From: Anita Gardner
Sent: 28 May 2019 14:47
To: Planning.Responses
Subject: FW: P1497ii - Rudford Ind Estate S73 - Comments
Attachments: 6606 (05) 001 E.PDF; 6606-(PL) 006 D.PDF; 6606-(PL) 007 D.PDF

Please find attached the revised drawings to replace those currently submitted under the NMA Application. These represent the following changes:

Drawing Title
**PROPOSED SITE BLOCK PLAN,
SITE LAYOUT & ELEVATION**

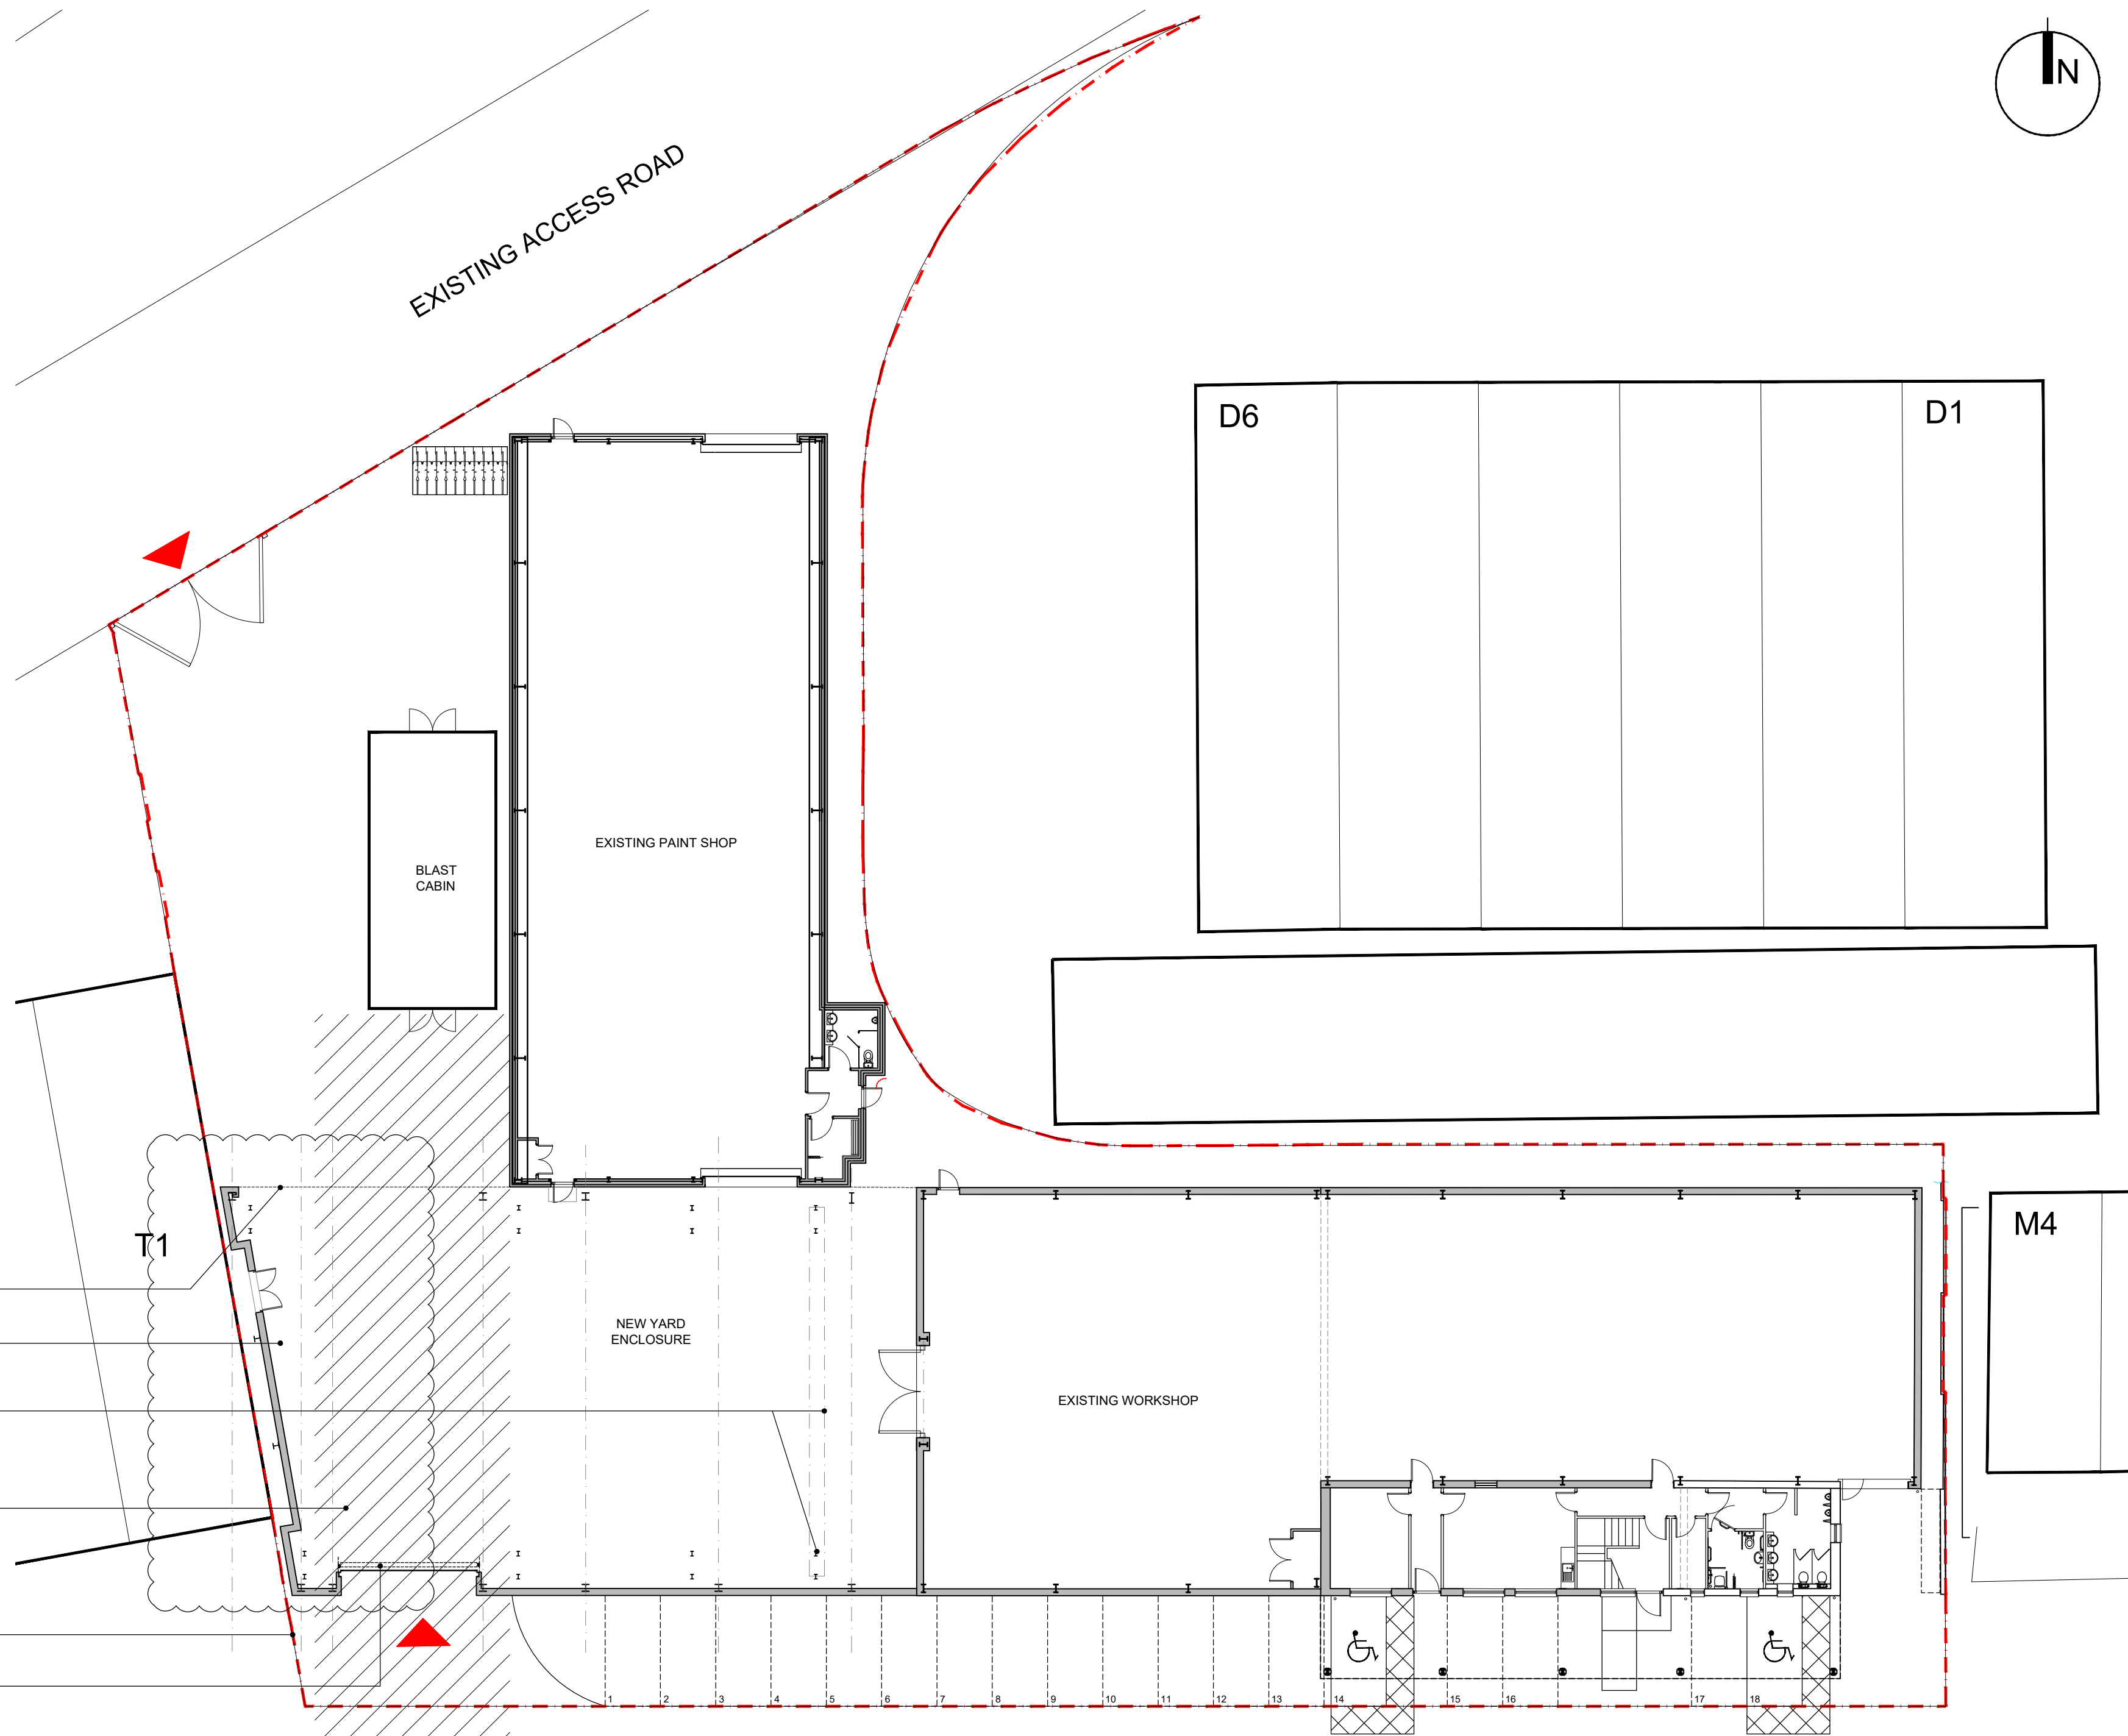
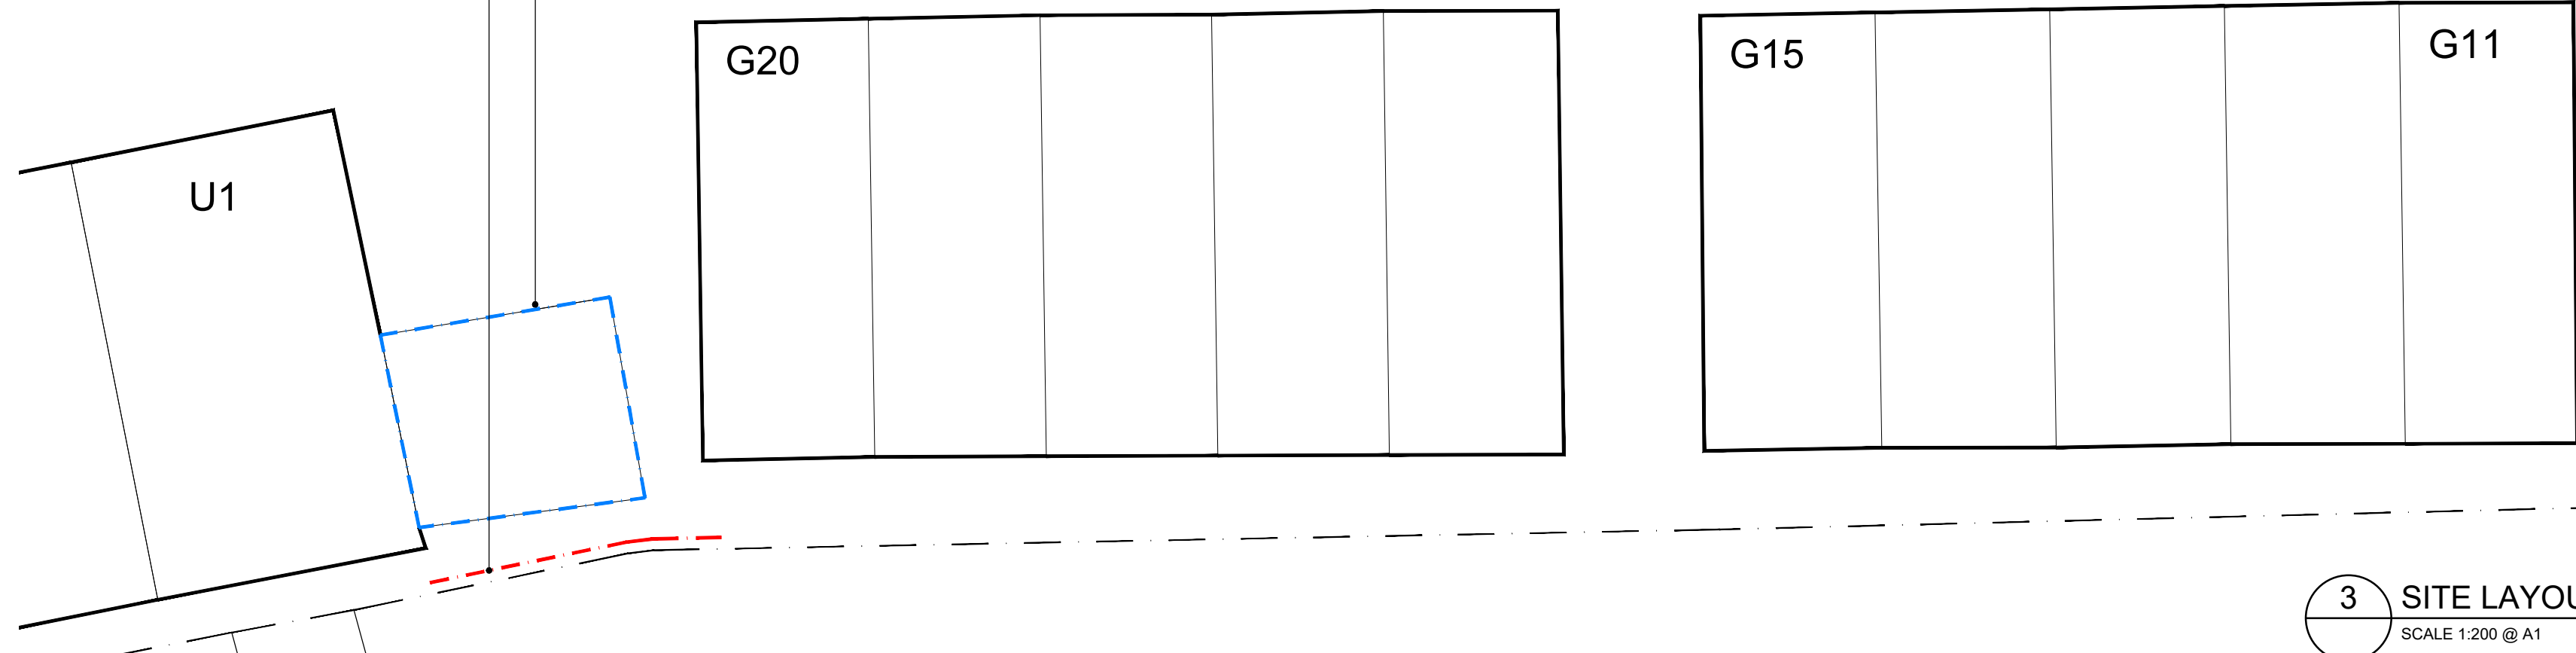
- (i) Setting back of the mid-section of the Western elevation to allow access relating to the existing Easement with the neighbouring building
- (ii) Access door to the void between buildings for service/maintenance purpose only
